Mr D Cullingford
Lead Member of the Examining Panel
M42 Junction 6 DCO Hearing
The Planning Inspectorate
Temple Quay House
2 The Square
Bristol BS1 6PN

28th October 2019

**Re. Representation submitted on behalf of David and Camilla Burton
Church Farm Accommodation, Church Lane, Bickenhill B92 0DN
Deadline 7 Submission**

**OPTION 1: INDICATIVE ALT. ARRANGEMENT TO REDUCE IMPACT ON CHURCH FARM LAND**

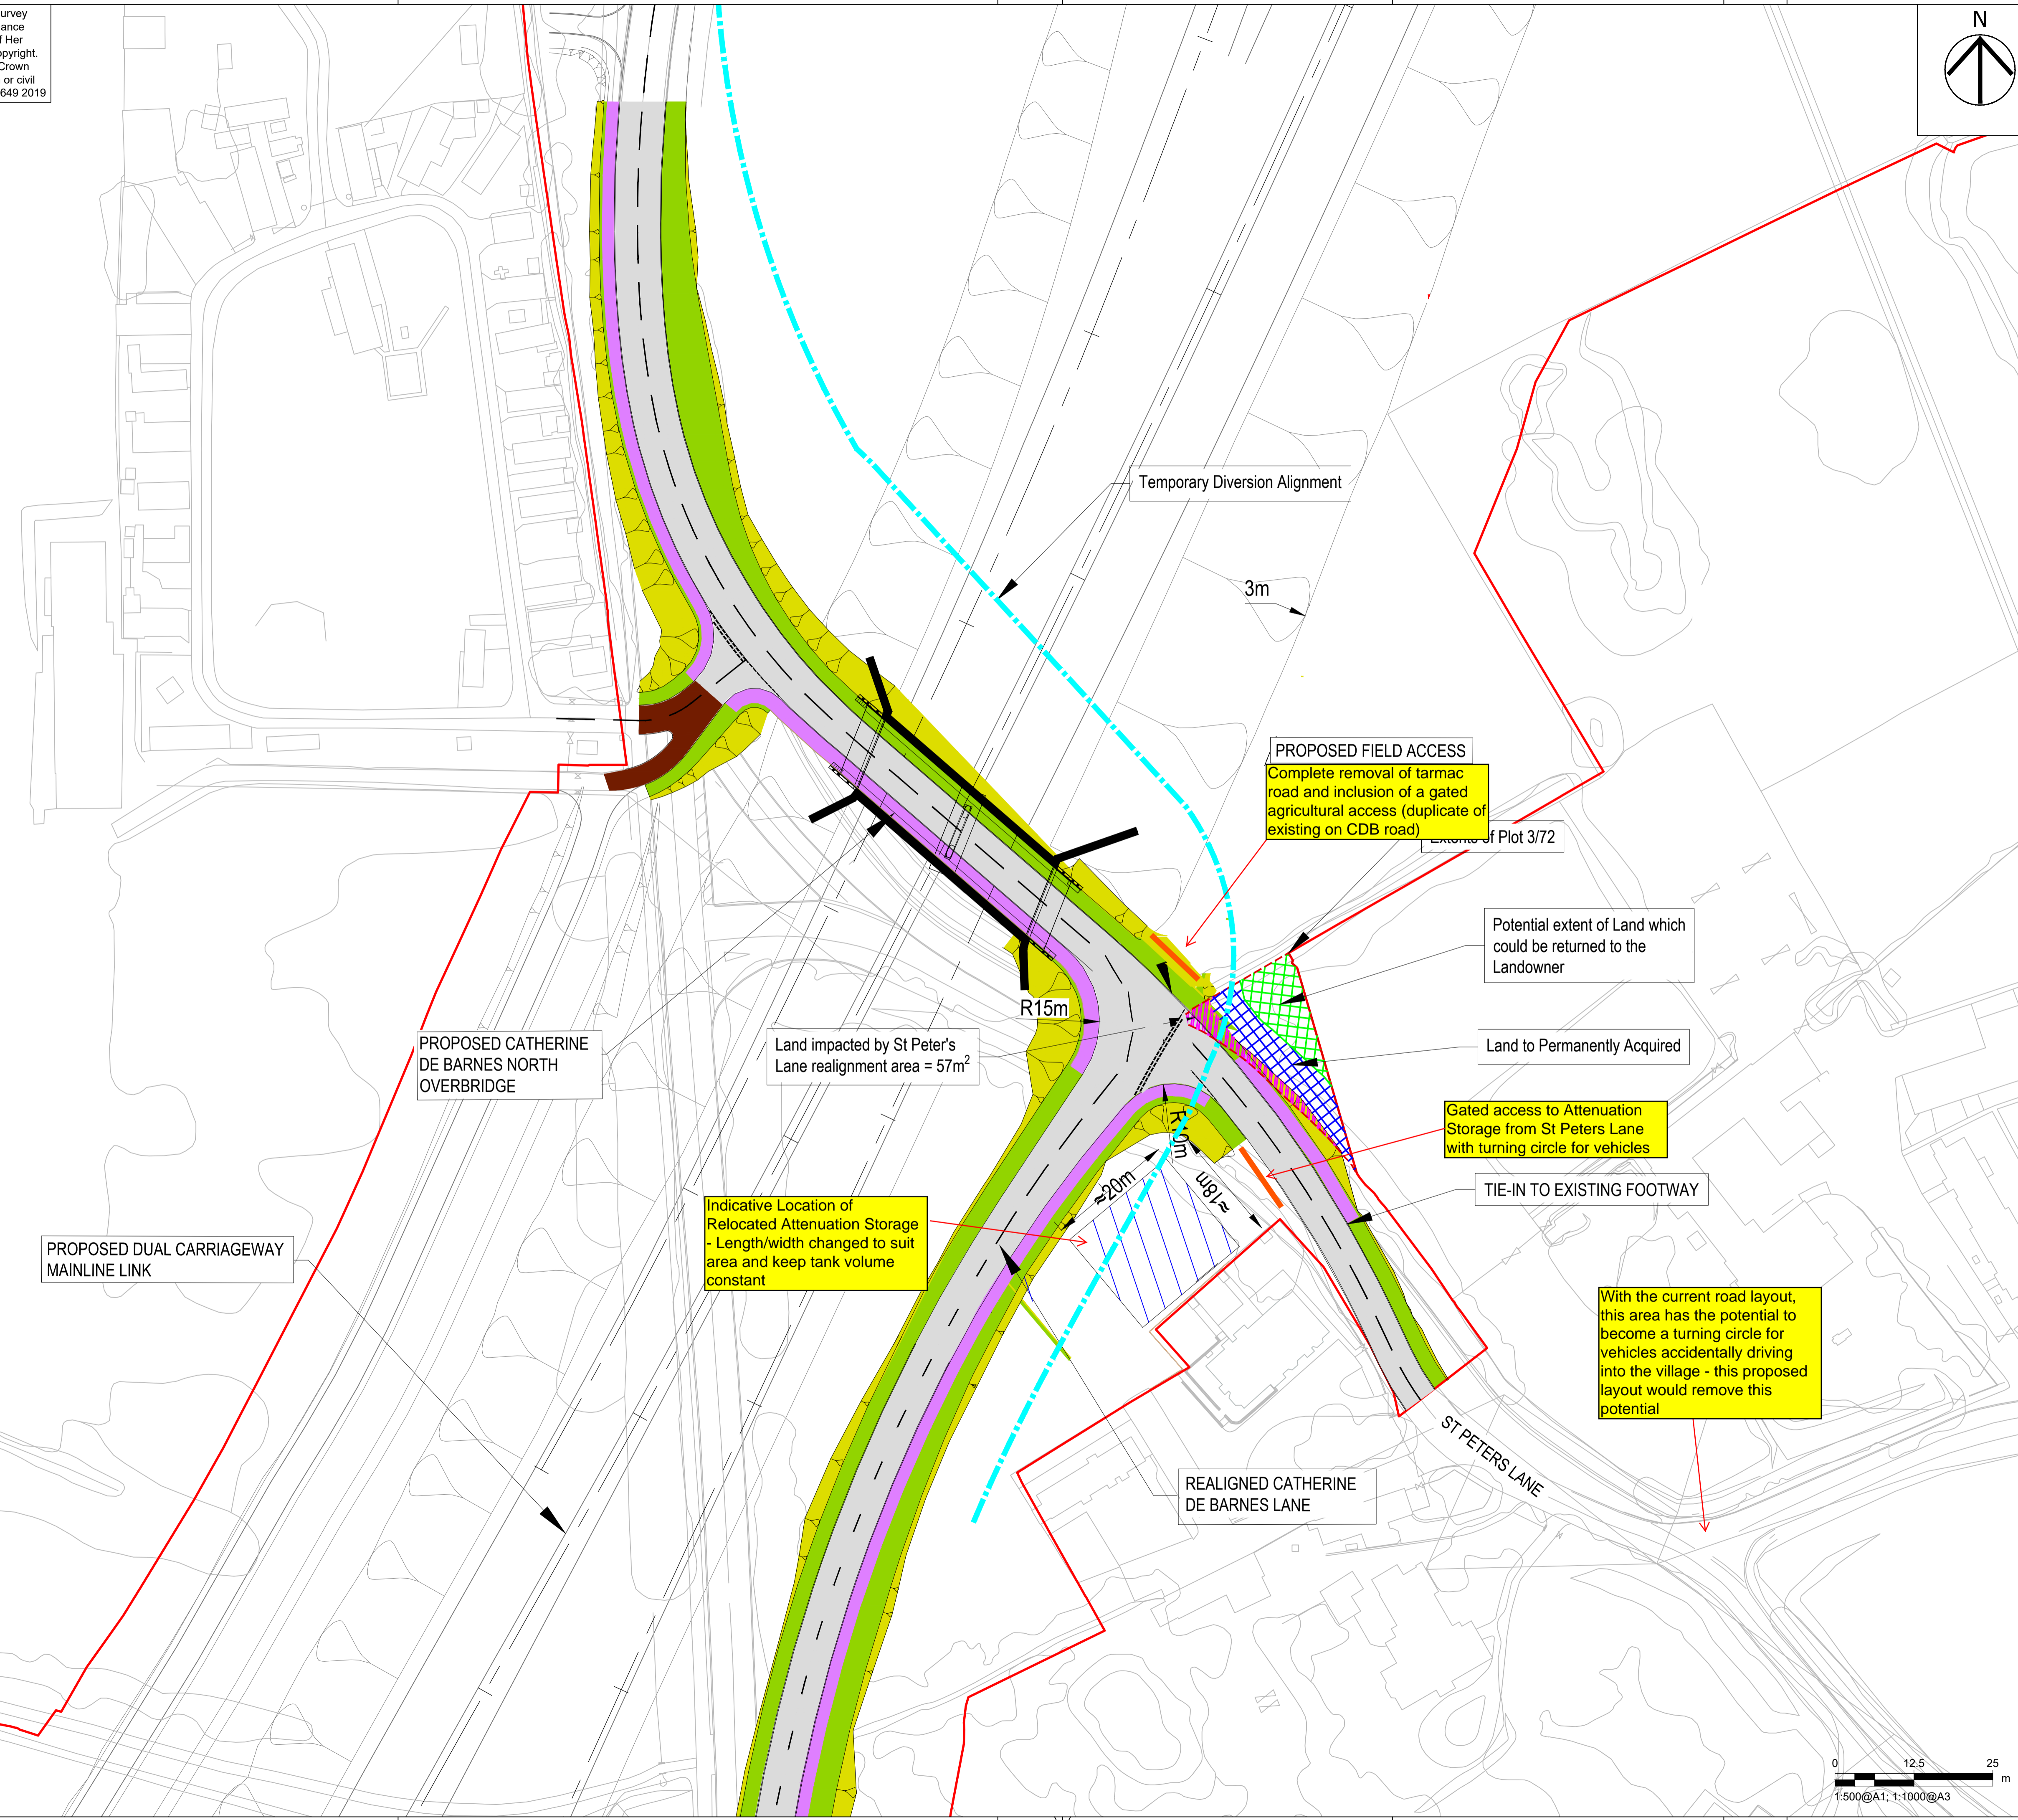
1. **Attenuation Tank and Access Track off realigned Catherine-de-Barnes Lane and St Peters Lane (please see Appendix 1 'St Peters and CDB Junction Reconfigured' in support of the following comments):**

- a) We do not believe that the junction of St Peter's Lane and the Catherine-de-Barnes Lane is appropriately designed at present, particularly for the period during the construction of the new road, as all traffic using the re-aligned Catherine-de-Barnes Lane will effectively be directed in to the centre of Bickenhill Village unless the priorities are changed – thereby causing severe damage to the village environment, including old and historic buildings, roadside verges, highways and the resident's peaceable and quiet enjoyment of the village and its surroundings. Such change would occur despite the Conservation Area status of the village. We support the Inspector and Bickenhill Parish Council in requesting that the vehicular priorities are changed from those currently being shown at the junction, even if that ultimately requires a modification to the alignment of either road. Preventing

- traffic, including construction traffic potentially exiting the site compounds, from travelling directly in to the centre of Bickenhill Village is a key priority.

- b) We welcome HE's assessment of the 4 options for the attenuation tank, and were pleased to note their comments (Doc 8.73, Action 3) that any one of the options was possible, and would not require the proposed gravity system to be modified to a pumped drainage system, and furthermore that the applicant had flexibility to implement any of the options.

- c) We were **not satisfied** that Option 3 had been fully and properly assessed in the light of the 3 key principals which the Inspector outlined at the beginning of each day of the Hearing.

- d) We noted that the proposed attenuation tank has a surface area of 360 sq meters on HE's latest drawings, and from our own measurements it appears as though a tank of about that capacity together with an access point and short section of service track can be satisfactorily incorporated within Plot 3/68b on east side of realigned Catherine-de-Barnes Lane and to the South of St Peter's Lane.

- e) From our own measured survey of the area in question, we believe that there is sufficient room within that residual area to incorporate a tank measuring approx. 15m x 24m (or of similar dimensions), together with a max 4.5m wide access gateway off St Peter's Lane. Such gateway to lead to a Y-shaped parking and turning area within the compulsorily acquired land forming part of Plot 3/68b to enable easy vehicular access/egress to the attenuation tank.

- f) We submitted our own annotated drawings directly to the Examining Authority last week to indicate this re-design option.
 - g) For clarity we believe that the ownership of the residential properties which are situated to the immediate east of Plot 3/68b falls to the same individuals / family name as the ownership of Plot 3/68b itself, and so far as we are aware neither the owner nor the tenants / occupiers of those residential properties and the adjoining grass paddock have submitted significant objections to the Scheme, or taken part in any of the Public Hearings.

- h) The potential for locating the attenuation tank to the south of St Peters Lane (Option 3) was previously dismissed because of the requirement for a service layby on the re-aligned Catherine-de-Barnes Lane. However we do not believe that such layby would be necessary given HE confirmation that the attenuation tank will probably only need to be accessed by the Drainage Authority once in every 6 months or so (subject to SMBC confirmation), as acknowledged at last week's Compulsory Acquisition Hearing. Therefore a straight agricultural field access (ie gate and hard-surfaced area) in to the land around the tank, to be taken directly off St Peter's Lane between the junction with the re-aligned Catherine-de-Barnes Lane and the edge of the village might well be the best possible solution.

- i) The available area for the attenuation tank in the residual part of 3/68b looks to be no smaller than the combined residual area within 3/73 a and b.

- j) We would respectfully request the Inspector to consider whether **modified Option 3 as above is a "more reasonable" solution** than HE's Option 1 or Option 4 for the tank, given the level of representation which has been made and the impact that either Option 1 or Option 4 will have on the neighbouring residential and commercial properties as a consequence of the adverse points relating to those Options which have been clearly set out to the Panel in previous evidence and correspondence.
